From: Amanda Scholes on behalf of Planning.Responses
Sent: 11 October 2017 10:04
To: Planning Scanning
Subject: FW: K/29/17/PL

Re K/29/17/PL

Mrs V Knight
Clerk to Kingston Parish Council
33 The Ridings
East Preston
West Sussex
BN16 2TW

PROPOSED FIRST FLOOR PLAN

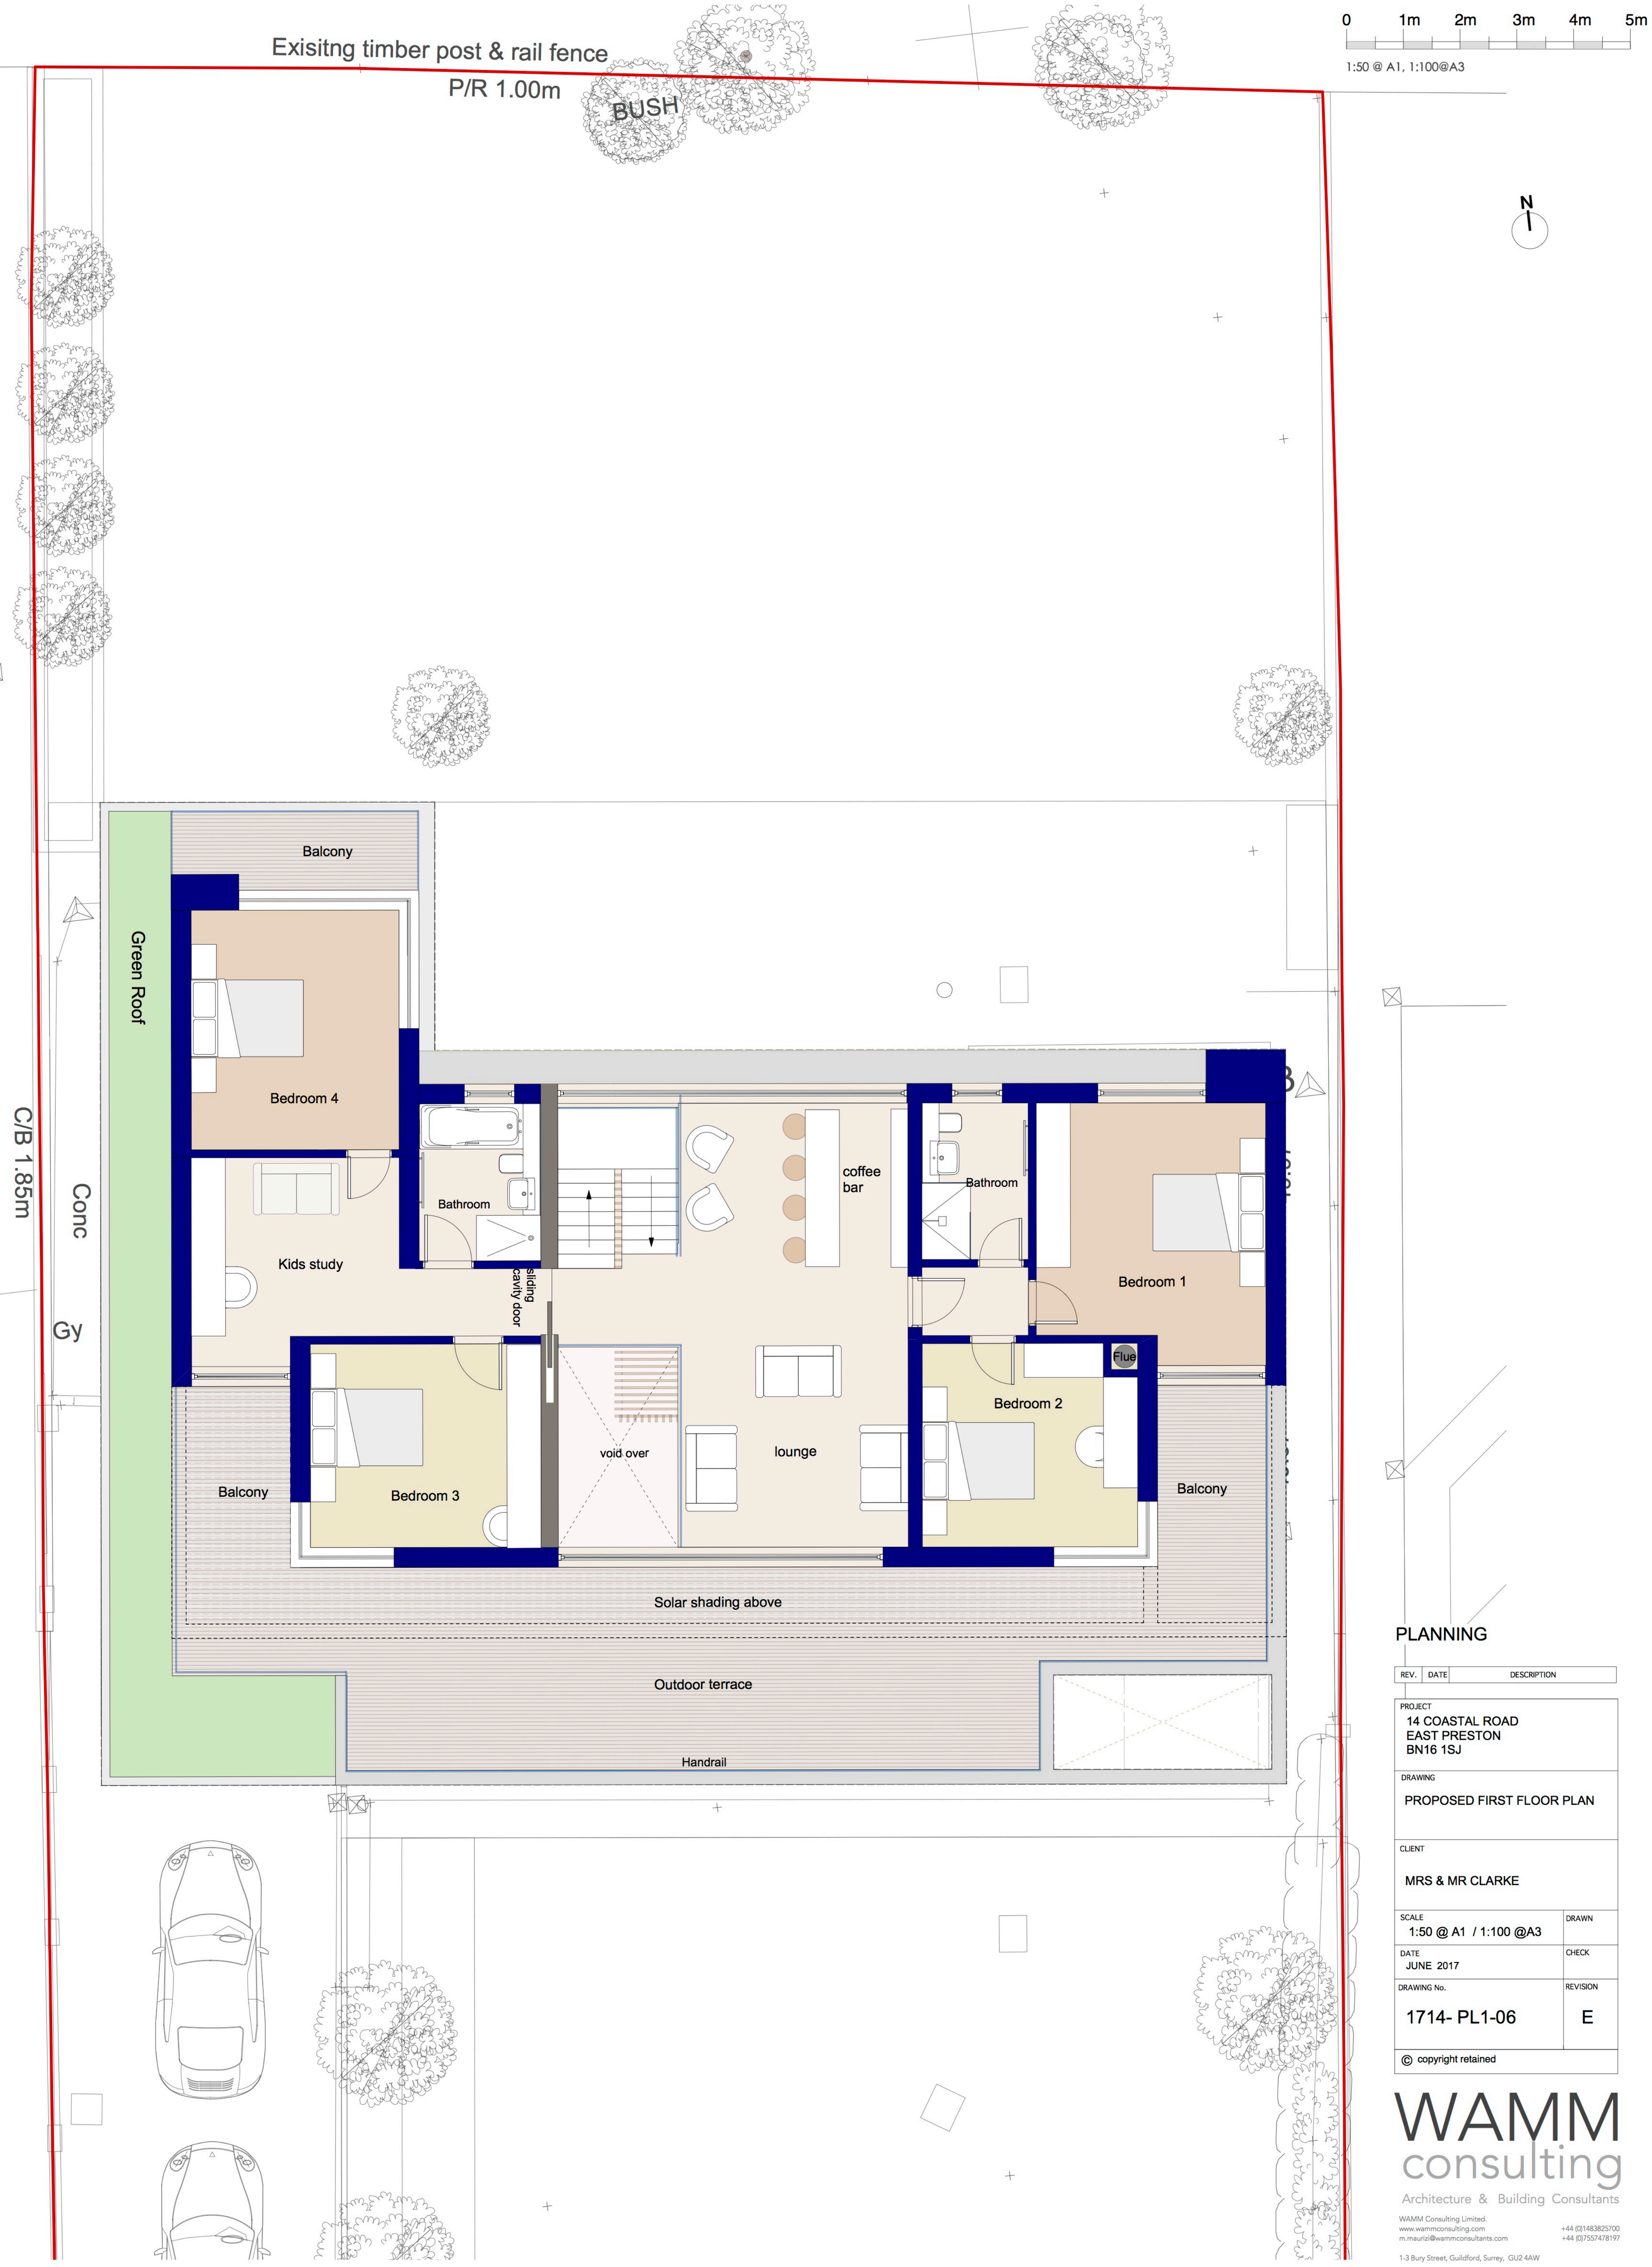
- Council is disappointed that the design of this application is contrary to the Kingston Design Statement.
- Council asks that to protect the privacy of neighbours where appropriate on the first floor and above, there are conditions that obscure glass and fixed openings are used on overlooking windows and privacy screens fitted to balconies .
